Scopwick & Kirkby Parish Council

Response to the Fosse Green Application

Reference: F213E4E19

Scopwick & Kirkby Green Parish Council objects to the Fosse Green application.

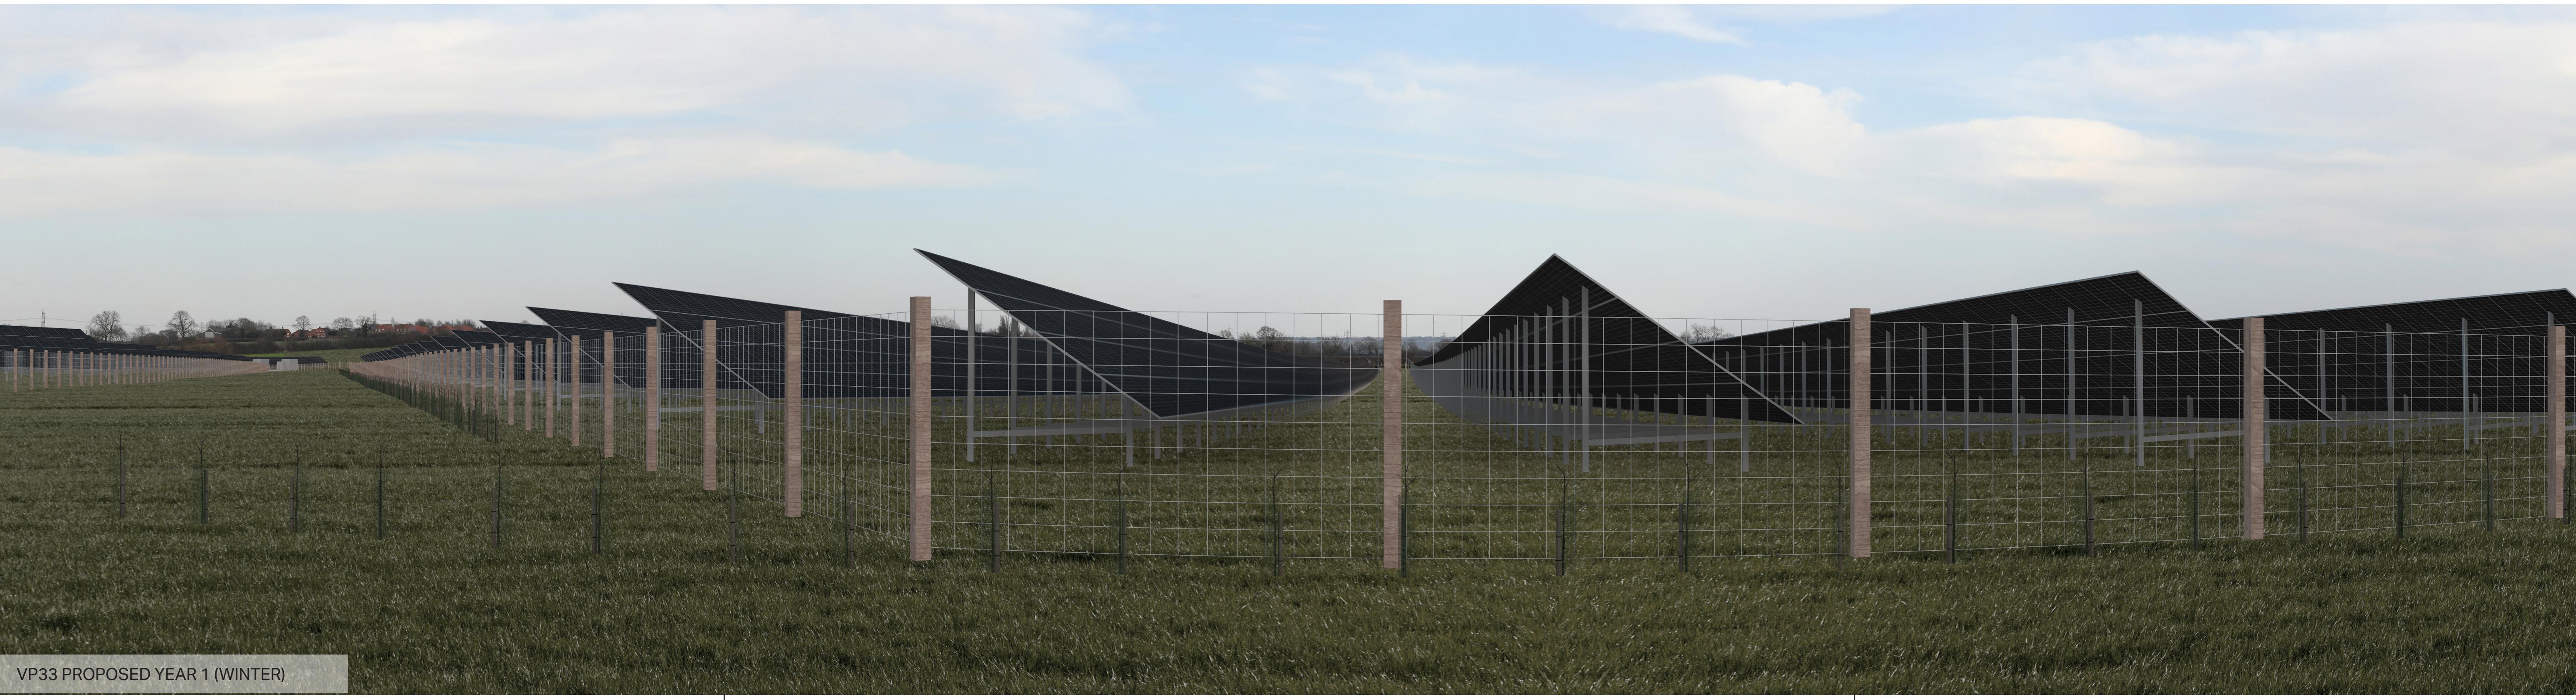
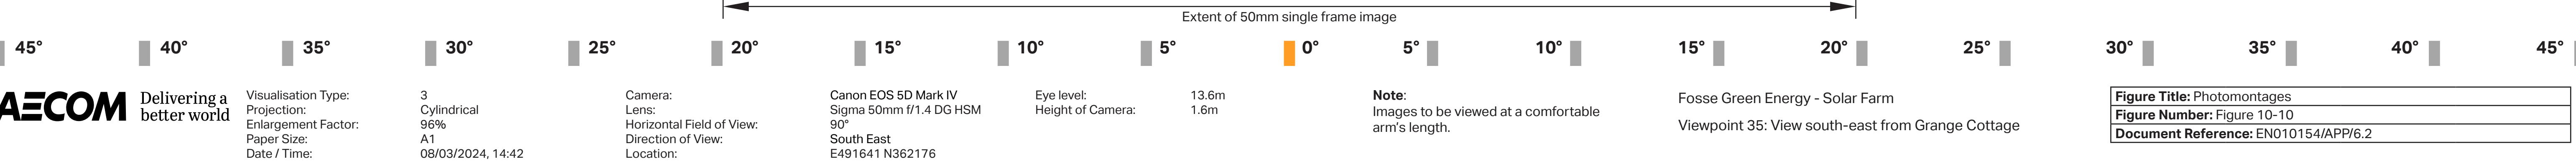
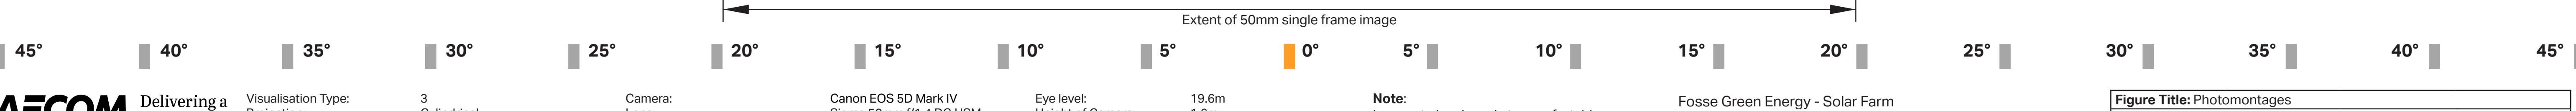
The submitted photomontages rely heavily on proposed hedgerow planting, without adequately acknowledging that such screening may take a decade or more to establish, if it succeeds at all. In addition, equivalent visualisations are not provided for Battery Energy Storage System (BESS) compounds, resulting in an incomplete and potentially misleading representation of the scheme's true visual impact.
